2023/0659

Address: 8 Alton Way, Staincross, Barnsley S75 6EY

Description: Erection of proposed single storey porch extension to front of dwelling, demolition of existing garage to side replaced with erection of two storey side extension (including integral garage) and erection of two storey rear extension

Drawing Title
PROPOSED ELEVATIONS

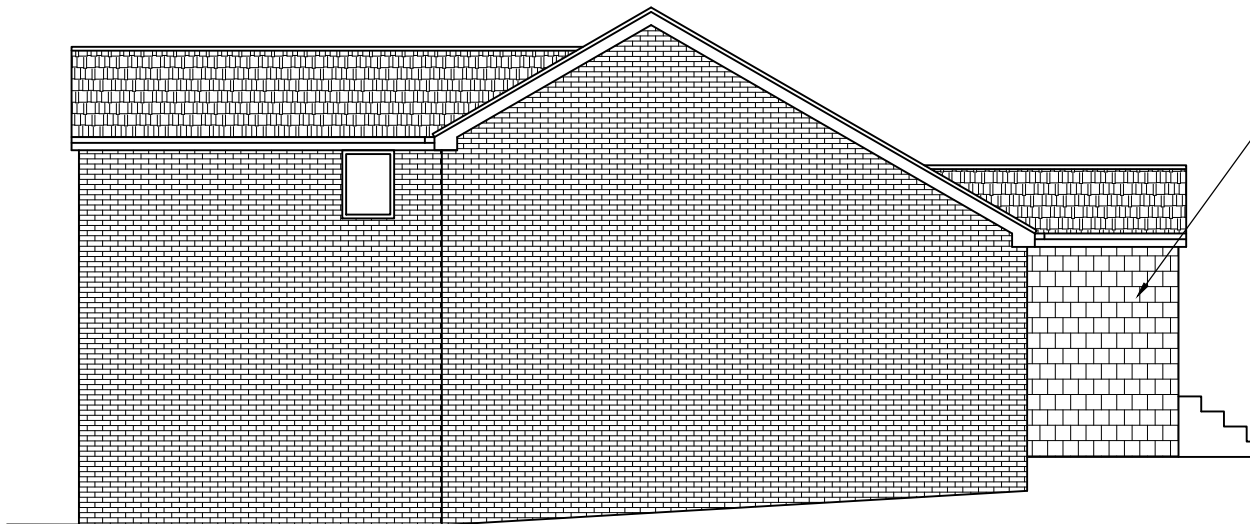
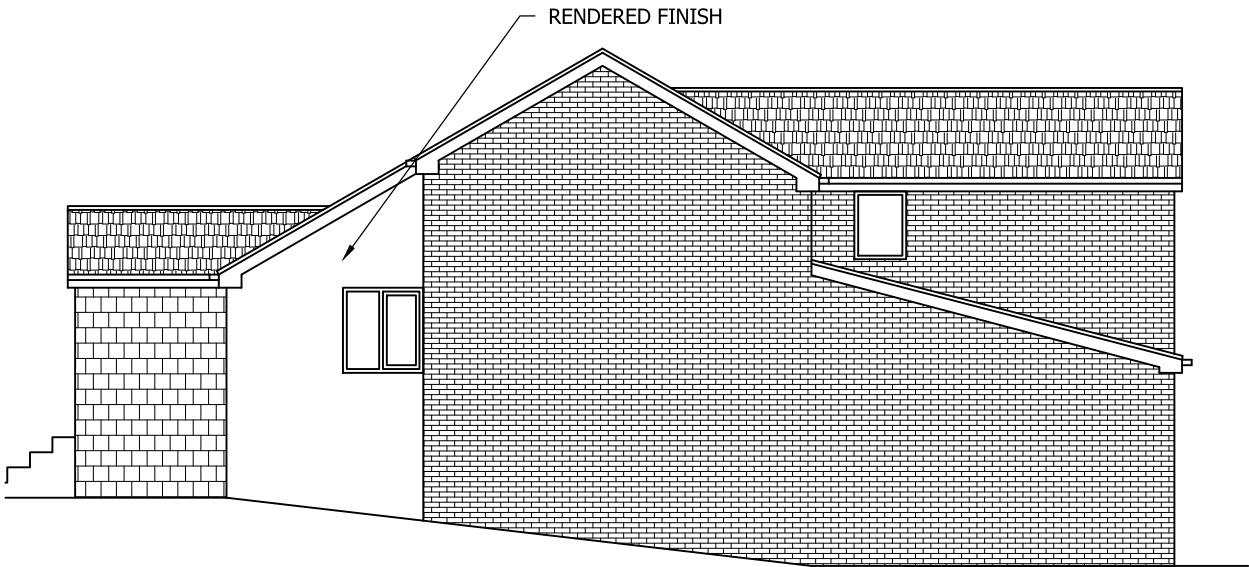
After advice, the original plans have been reconfigured to reduce the amount of proposed render and an increased retention of brickwork. Some small areas of design features, such as a stone porch and a smaller section of render have been retained, where in part, retaining or using matching brickwork may be difficult.

Starting with the rear elevation, which includes the proposed two-story extension, the proposals would not cause any harm to the visual amenity of the dwelling and although it may be partially seen from a distance, due to its elevated position, the proposals would not appear out of character with other dwellings, and in part would create better symmetry with the neighbouring extended dwelling at No. 6. The rear would feature a section of render, which would assist in concealing areas of brickwork where windows have been altered or removed,

The first-floor side extension and the front porch would provide the most significant visual changes to prominent front elevation of the dwelling. From an initial proposal for all render, the applicants have reducing this to predominately the original brickwork with a small piece of render, again

assisting in hiding where windows are altered or removed. A stone front porch has been proposed, which reflects the aspects of original stone cladding of the dwelling and other dwellings on the street which feature stone or stone cladding.

PROPOSED GROUND FLOOR PLAN
SCALE 1:100 AT A3

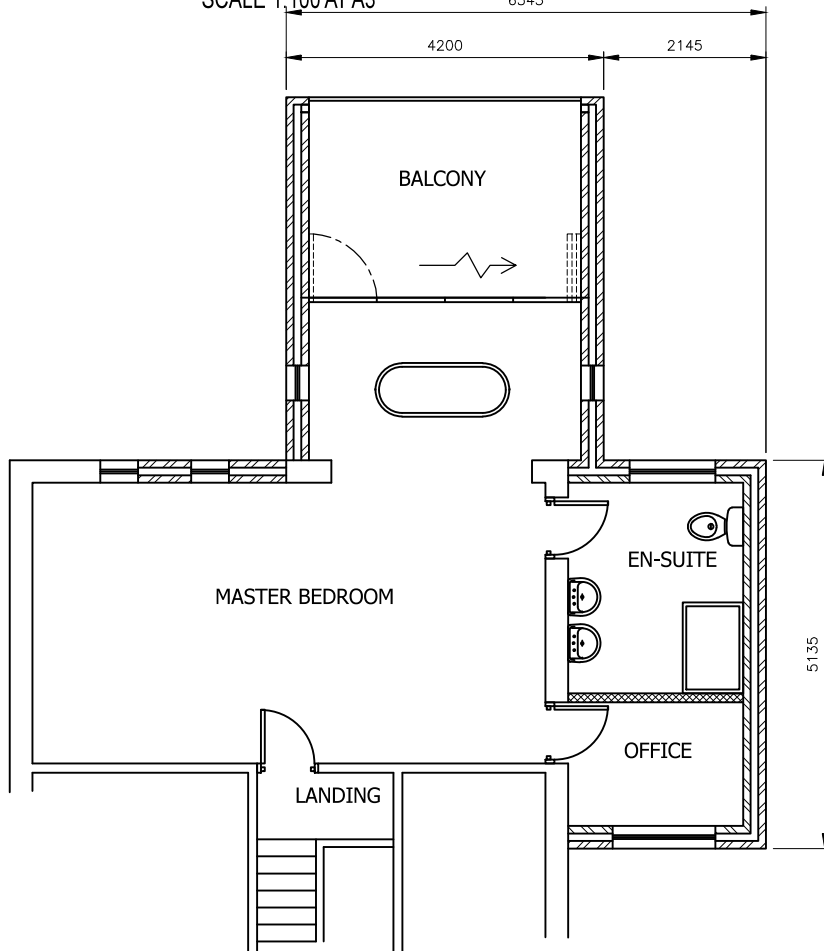
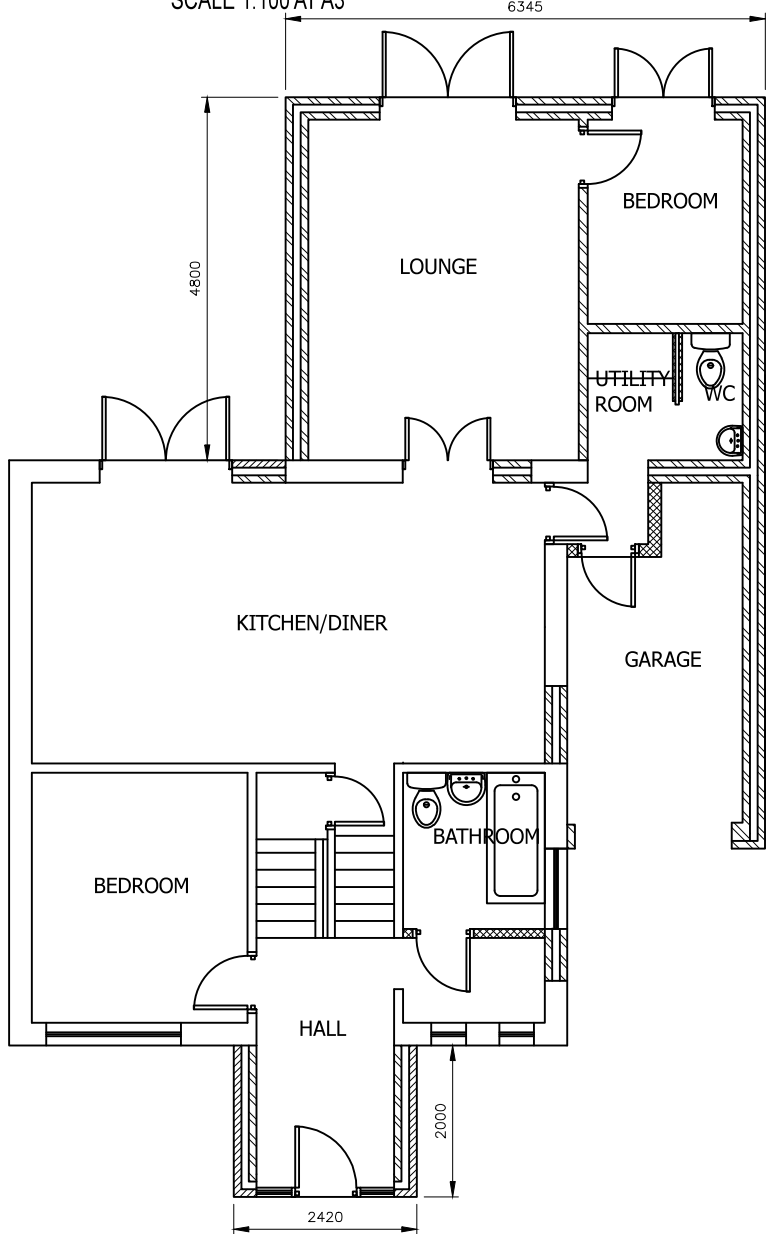
A desktop and site review of the proposed area for the extension and view from the proposed area was undertaken. The dwellings below on Kingsway currently face some overlooking and consequential loss of privacy to their rear gardens due to the way the estate was originally built, upon a steep hill with back-to-back gardens. It was difficult on site to confirm distance but there did appear to be a considerable distance between the dwellings. When the distances were checked on a map, a minimum distance of 29m is maintained between the rear boundary of the proposed extension and any dwelling on Kingsway.

Paragraph 7.5 of the Supplementary Planning Document (SPD) House extensions and Other Domestic alterations states that ***“As a general guide, windows to habitable rooms on an extended property should not be less than 21 metres from any other properties with habitable room windows, to ensure reasonable privacy to you and your neighbours.”*** As a minimum of 29m is maintained between dwellings, this is already 8m more than the guidance. Further consideration is that the proposed balcony is an internal balcony, resulting in the only rear facing, first floor window being set back a further 2.65m inside the proposed extension. Two small windows feature on the first-floor side elevations. Although the balcony is a concern, it would be unlikely to be used constantly and people using the balcony would be at least 29m away from dwellings to the rear, of which the first 13m would be looking into the applicant’s own garden. Because of the internal design of the balcony, there would be limited visibility of dwellings or gardens to the side of the dwelling. One final consideration is that a similar extension with internal balcony was approved in 2019 for the neighbouring dwelling at No.6

As both the balcony and window would far exceed the SPD’s 21m minimum distance requirement for windows, and that the dwelling on Kingsway are already unavoidably overlooked, the proposed two-story extension would not cause significant harm or loss of residential amenity to the dwellings on Kingsway or on Alton Way.
